From: Martyn White
Sent: 11 July 2019 17:07
To: Planning.Responses <Planning.Responses@arun.gov.uk>
Cc: Zac Denton <Zac.Denton@arun.gov.uk>
Subject: AB/54/19/L

AB/54/19/L

Listed building consent to repaint existing external rendered & painted wall (including woodwork such as windows & door frames) & change colour of rendered wall from cream to grey; woodwork will be repainted same colour (white).

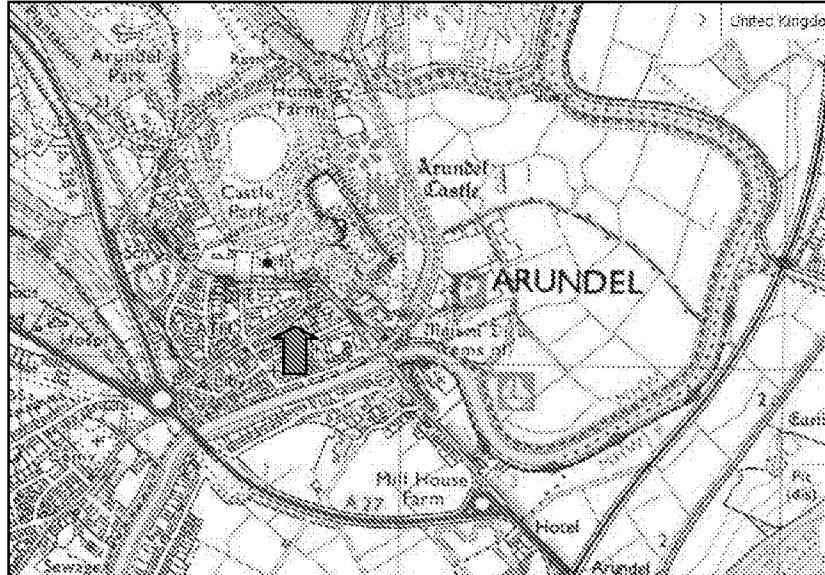
Whilst the concept of using another colour to paint the elevation may be acceptable, it is considered that the colour proposed is problematical. Without appropriate information to support the fact that such a colour is appropriate for the age/style of the building, or indeed is a colour from the period of construction, the proposal has to cause a level of harm.
